Objection Letter (Updated with CDC, Survey Evidence, EIS Inconsistencies, Structural Risk & Sunlight/Shadow Issues)

To: NSW Department of Planning, Housing and Infrastructure Re: SSD-83478456 - Residential Development (21-25 McIntosh St & 55 Werona Ave, Gordon) From: Owner - 12 Forsyth Street, Killara NSW

Drawing Title STORMWATER MANAGEMENT PLAN - GROUND SHEET No. 1					
Drawn	Date	Scale	A1	Q.A. Check	Date
IK	MAY 2025	AS SHOWN	A1	BK	21.05.2025
Designed	Project No.	Dwg. No.	Issue		
BK	CC250085	C5	A

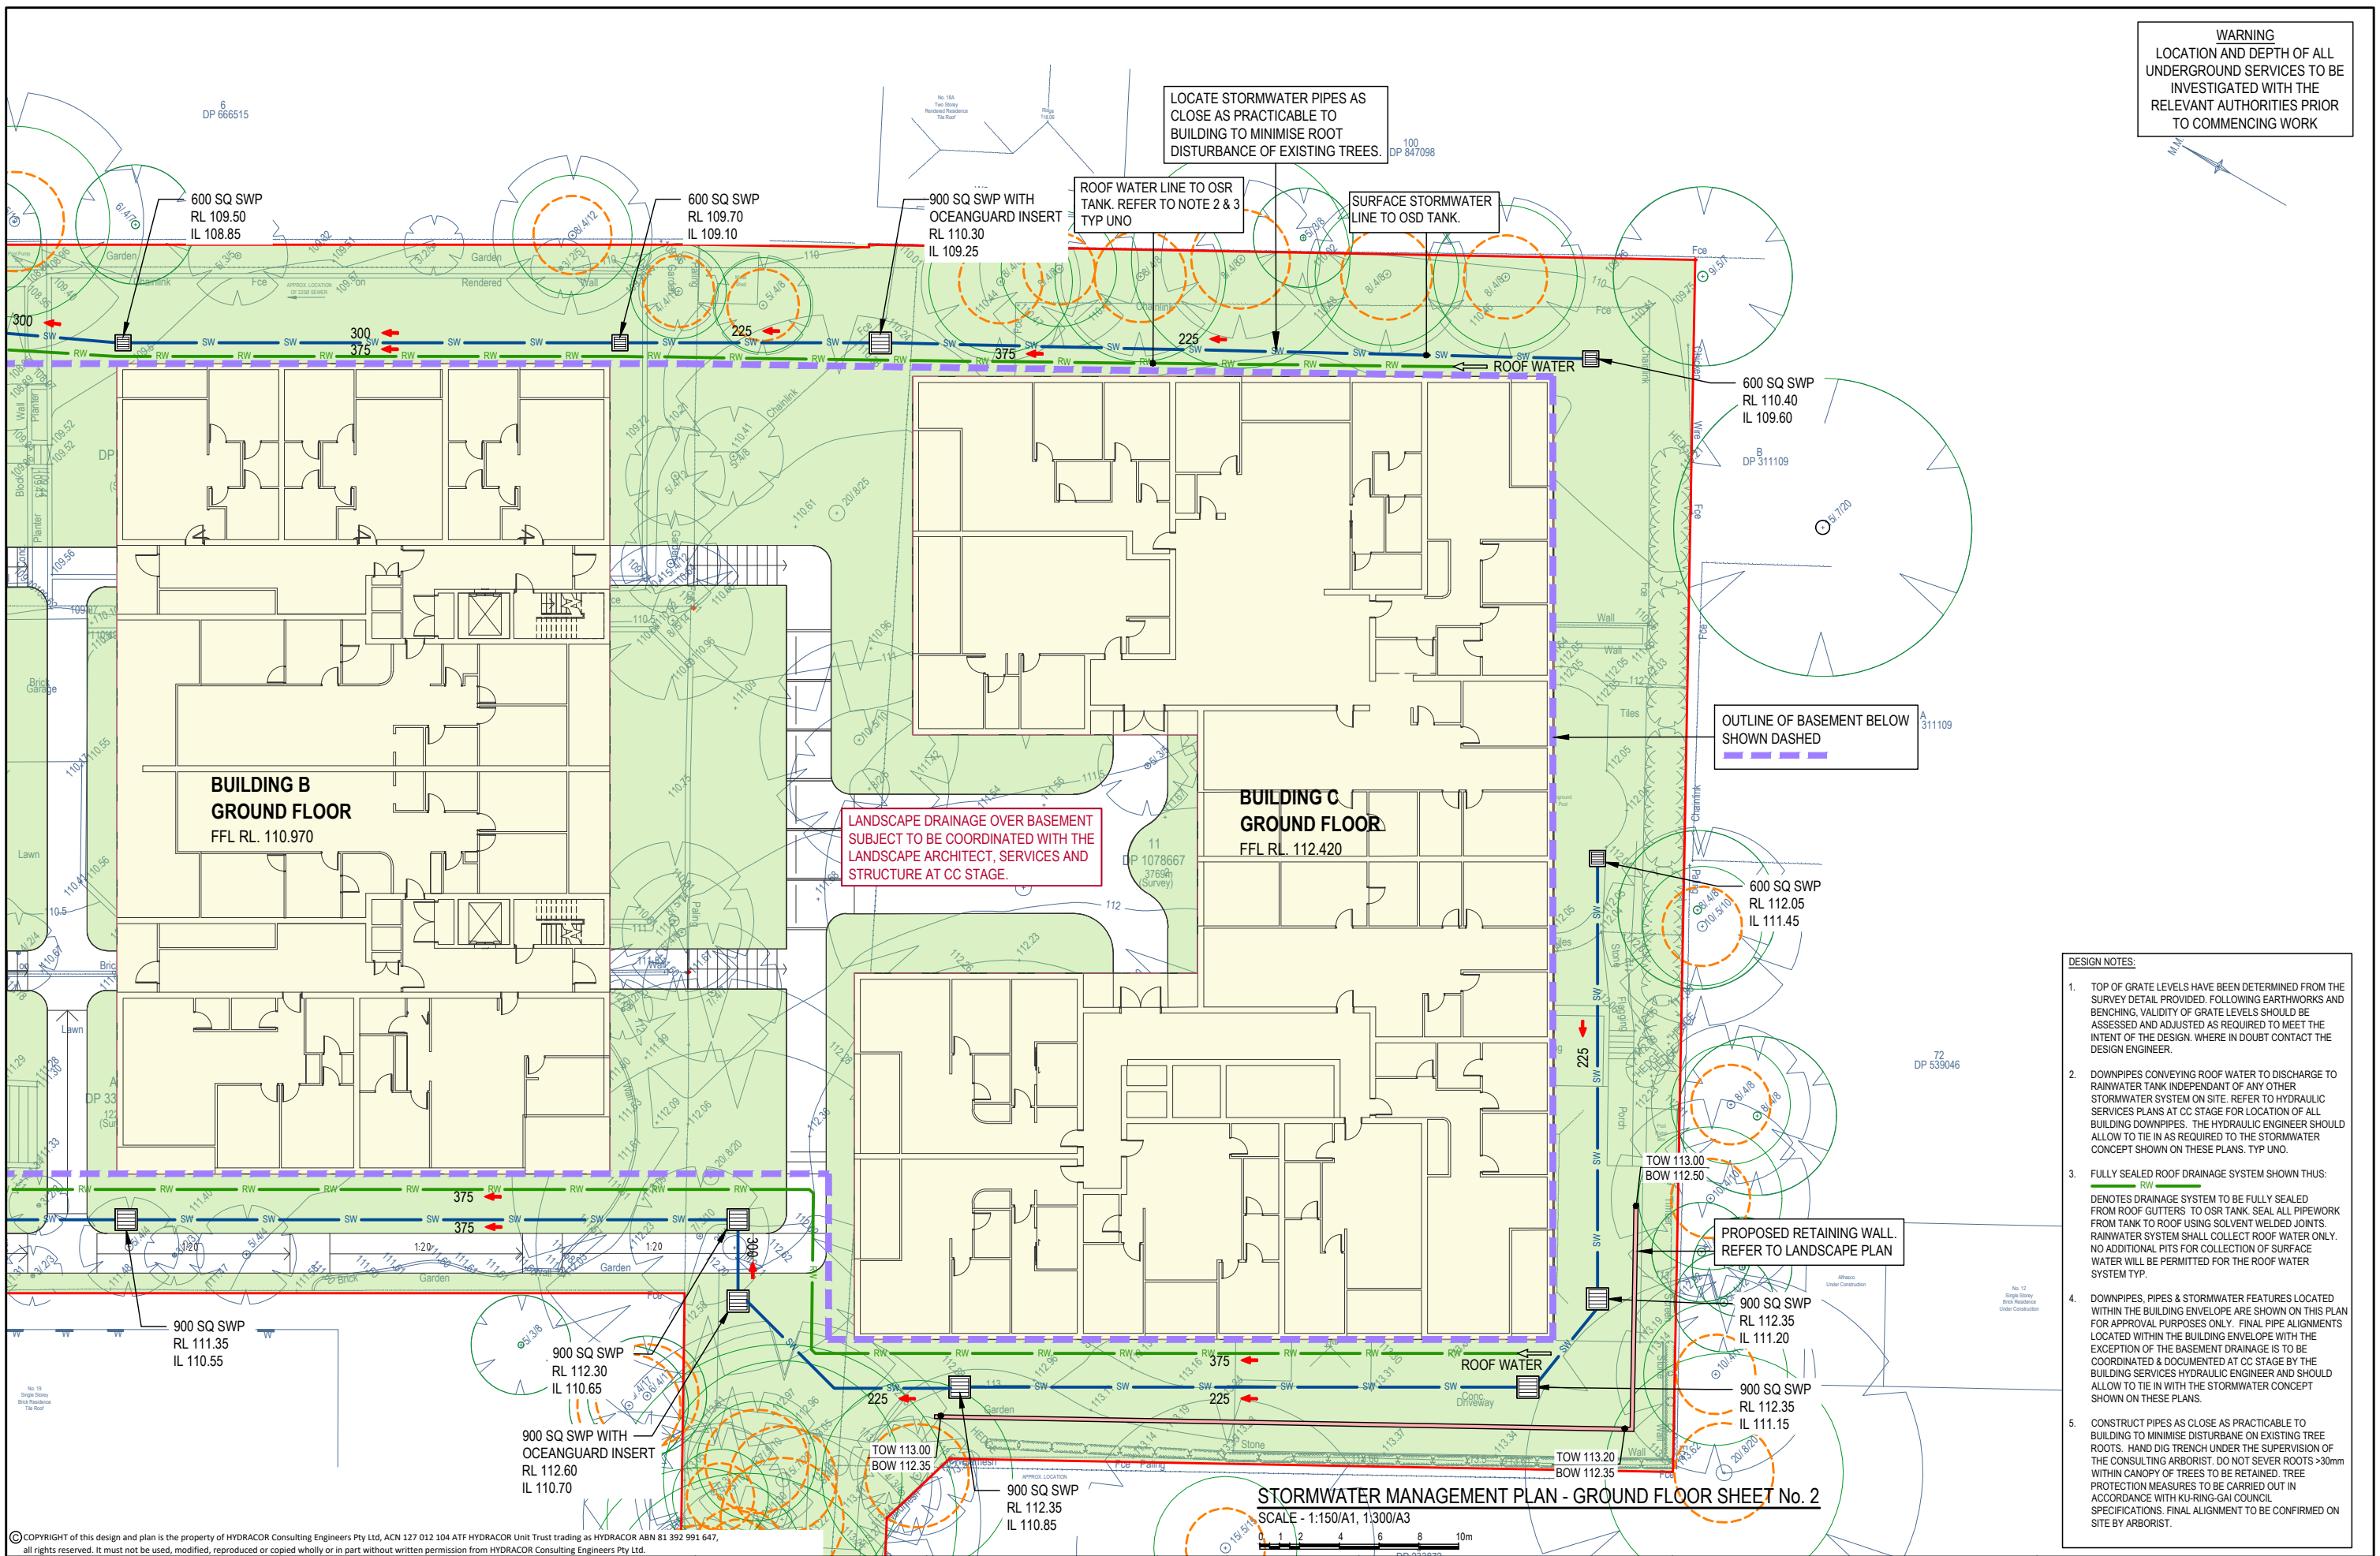
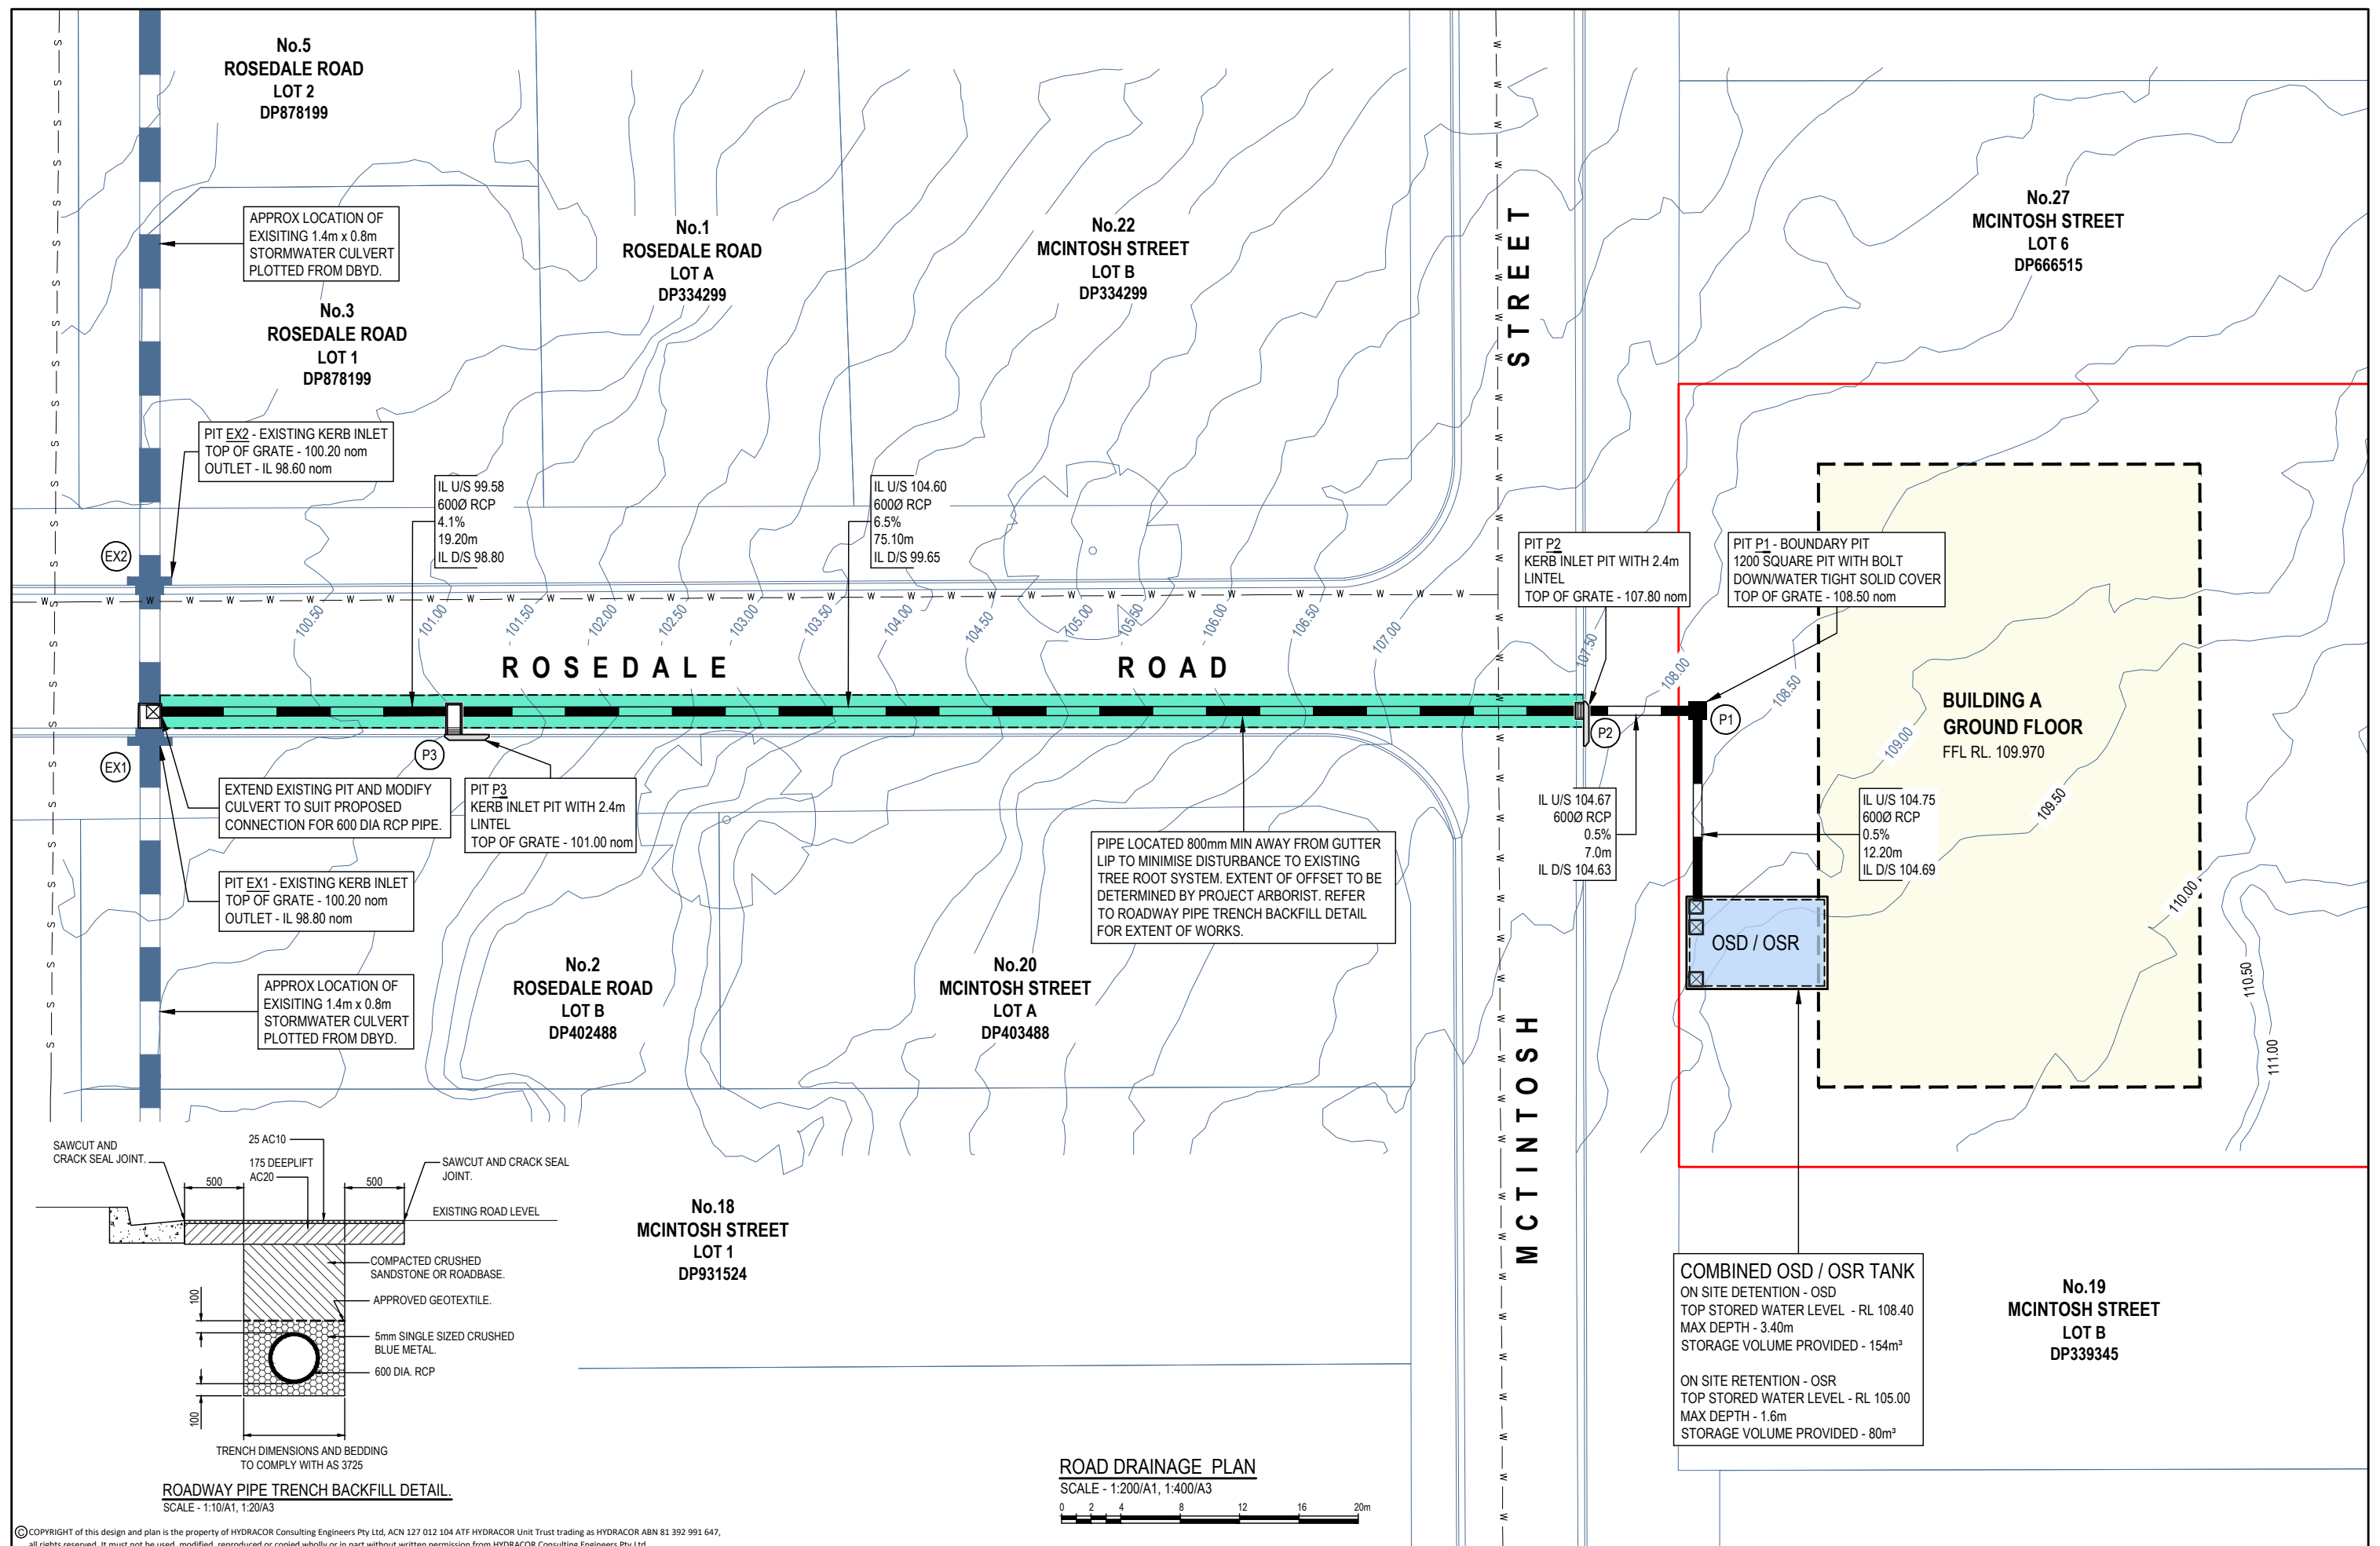
- Appendix Z - Stormwater Drawings (pages 1-9) contain multiple references to OSD tanks and overflow, but there is no consolidated table of required vs provided detention volumes, nor confirmation of Q100 overflow paths away from adjoining lots such as mine.
